Final Report - Corrections Required **Application No. SUBD-26-0048**

Description : Single family residential with optional ADU. 41 lots

Document Filename : FP Creekrdige at Flying Horse Filing No. 2 V2.pdf

CREEKRIDGE FILING NO. 2

LOT EASEMENT DETAIL
(LOTS 1-3, 5-6, 15-16, 18-19, 26)
(* - PRIVATE USE EASEMENTS TO BE DEDICATED
BY SEPARATE INSTRUMENT. SEE NOTE 11.)
N.T.S.

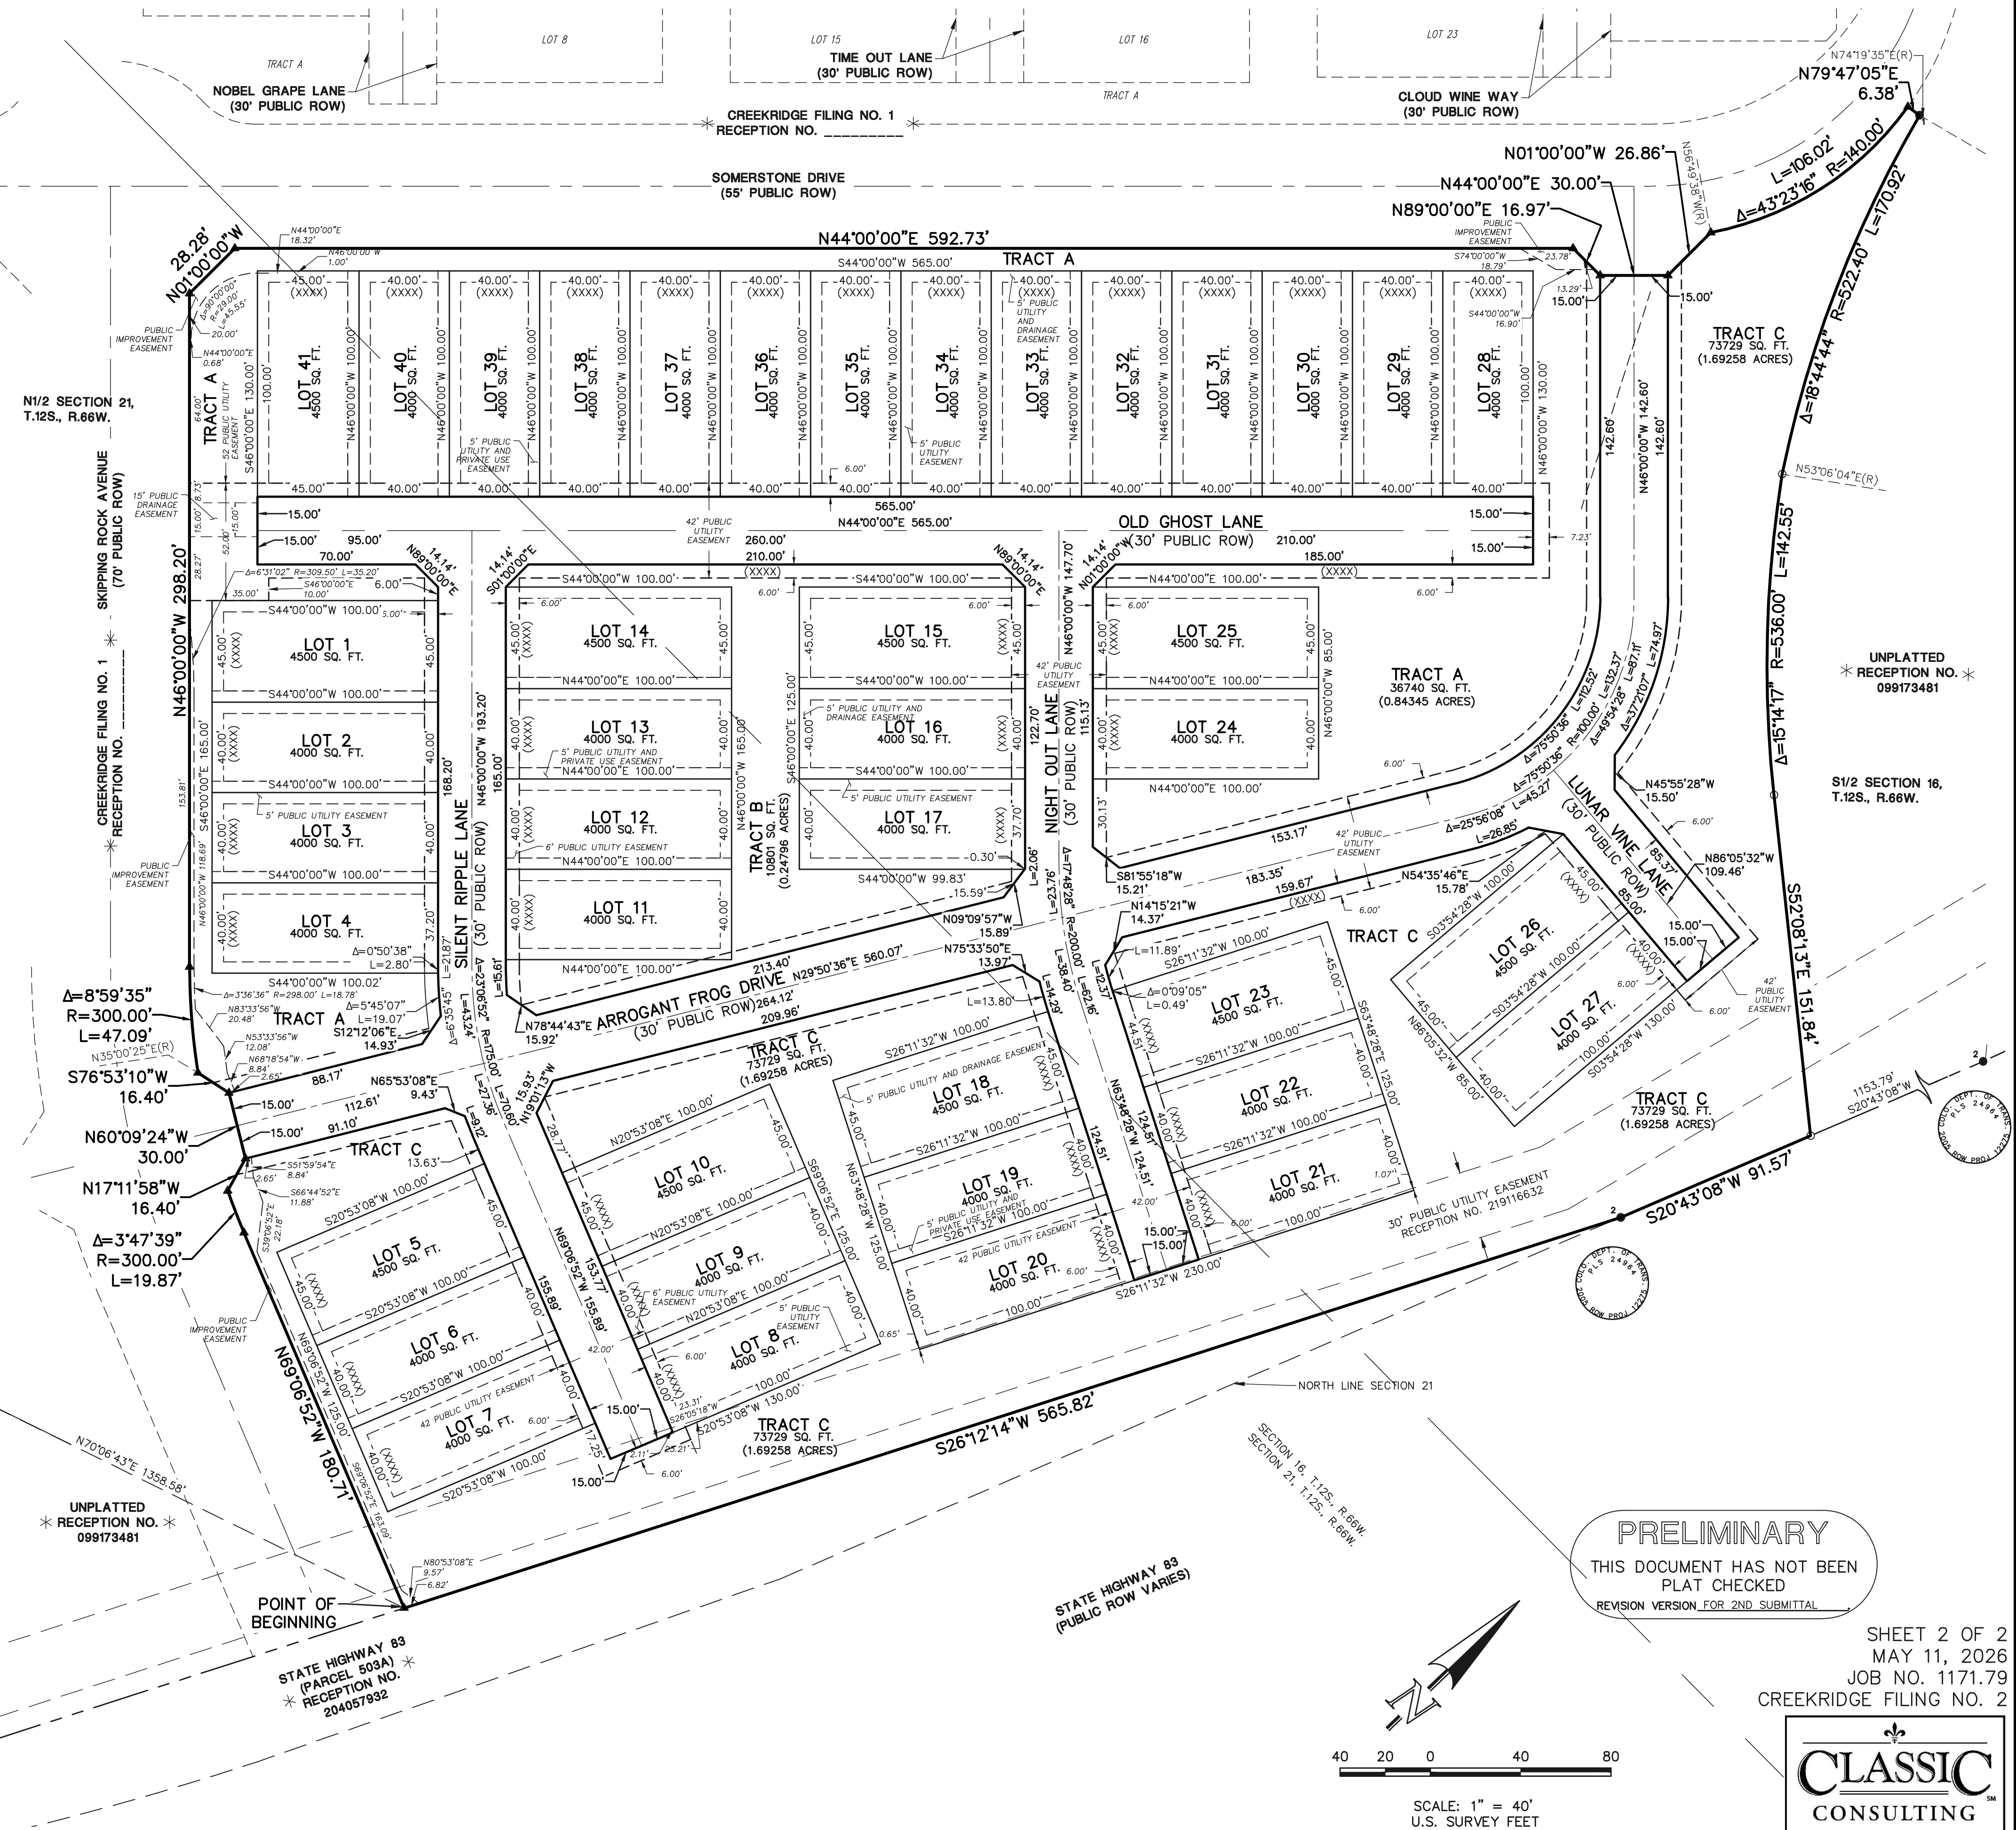
51	2	Cory Sharp : Planning	please revise "dedicated" to "conveyed" as dedicated only occurs on the plat for public easements
52	2	Cory Sharp : Planning	please note that there may be changes to the exterior boundary, as there on conversations on going for area along Powers Boulevard

please revise "dedicated" to "conveyed" as dedicated only occurs on the plat for public easements.
